White Hill Wind Farm

Annex 13.1: Stage I Road Safety Audit

White Hill Wind Farm, Co.
Carlow

Stage 1 Road Safety Audit

**Figure 13: Site Entrance on N78 & L1834**

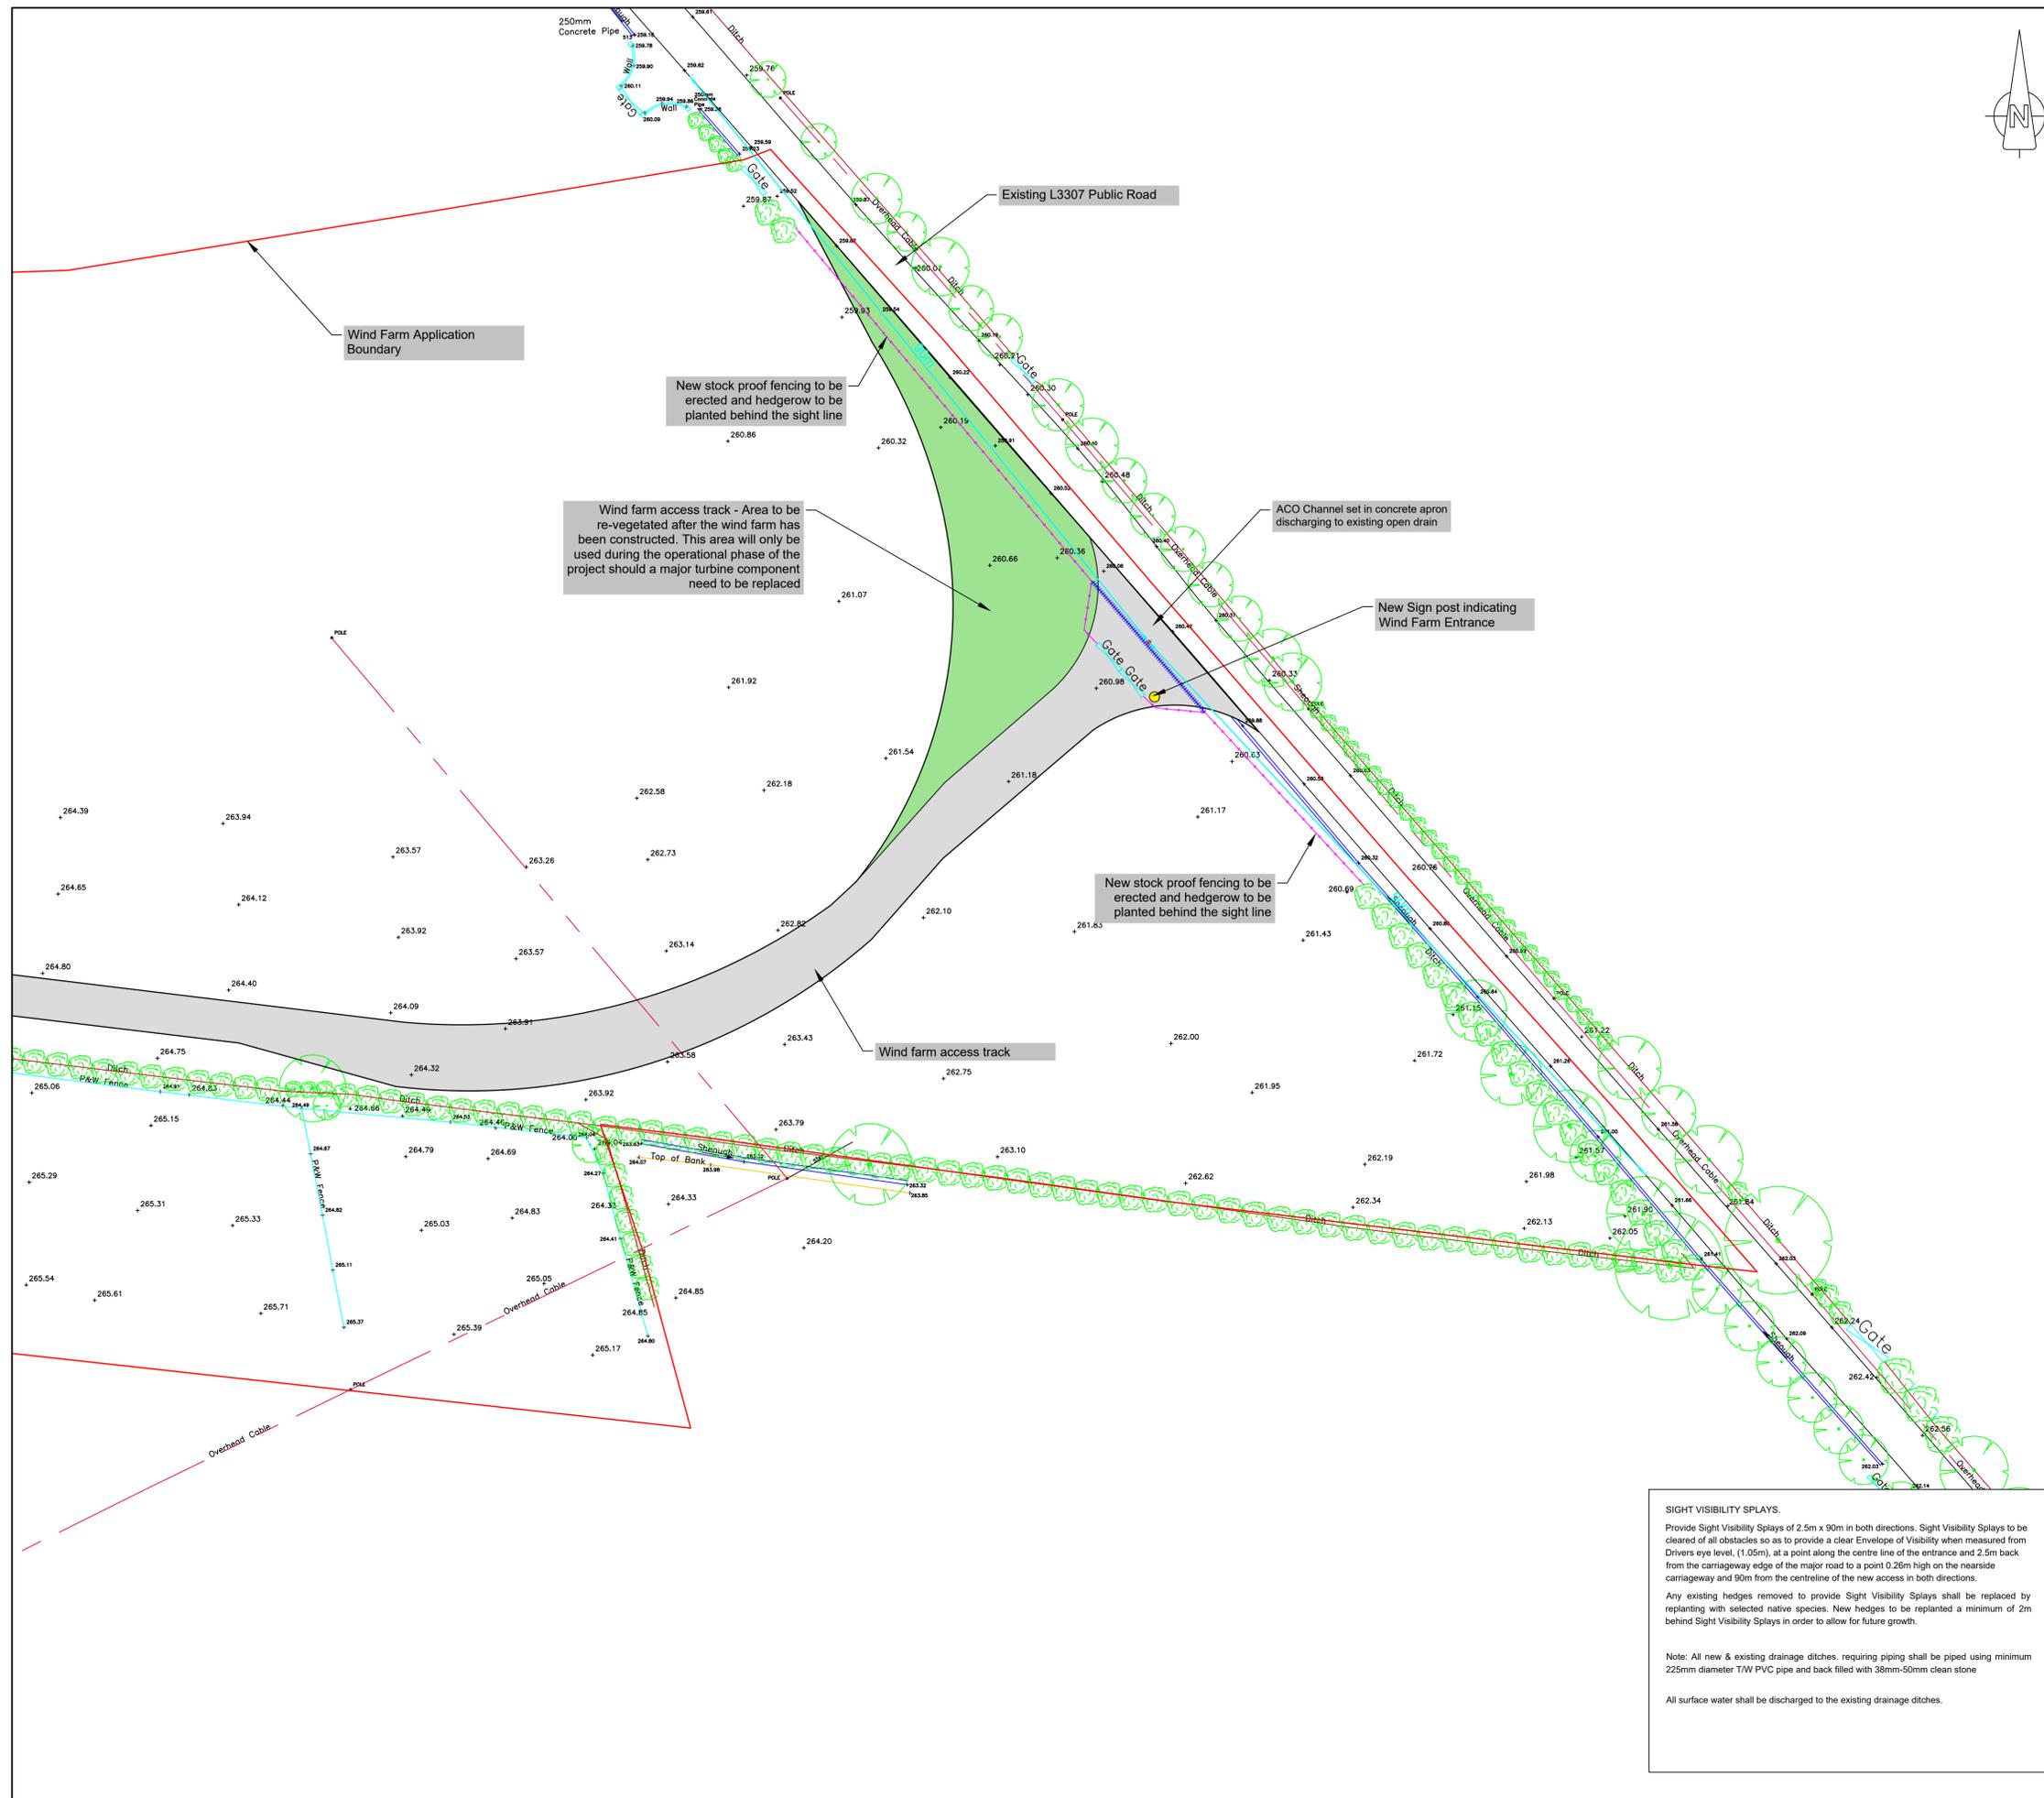
Open drain channels are located close to the carriageway edge on both side of the local road between the two proposed access junctions. A large vehicle could enter the drain channel leading to the vehicle becoming trapped or overturning.

Drainage measures should be provided to prevent large vehicles becoming trapped or overturning.

2.1	Yes	Yes	Existing roadside drainage channels will be filled as part of the carriageway widening works with new drains constructed to appropriately manage surface water.

The existing ground profile to the east of the access junction may result in an obstruction of the visibility splay leading to visibility issues for vehicles exiting the access junction.

The ground profile should be graded to ensure the access junction visibility splay is not obstructed.

2.2	Yes	Yes	The identified trees and overhanging branches will be removed as part of the carriageway widening works.	
2.3	Yes	Yes	All ground levels will be graded such that they do not interfere with the provision of visibility splays.
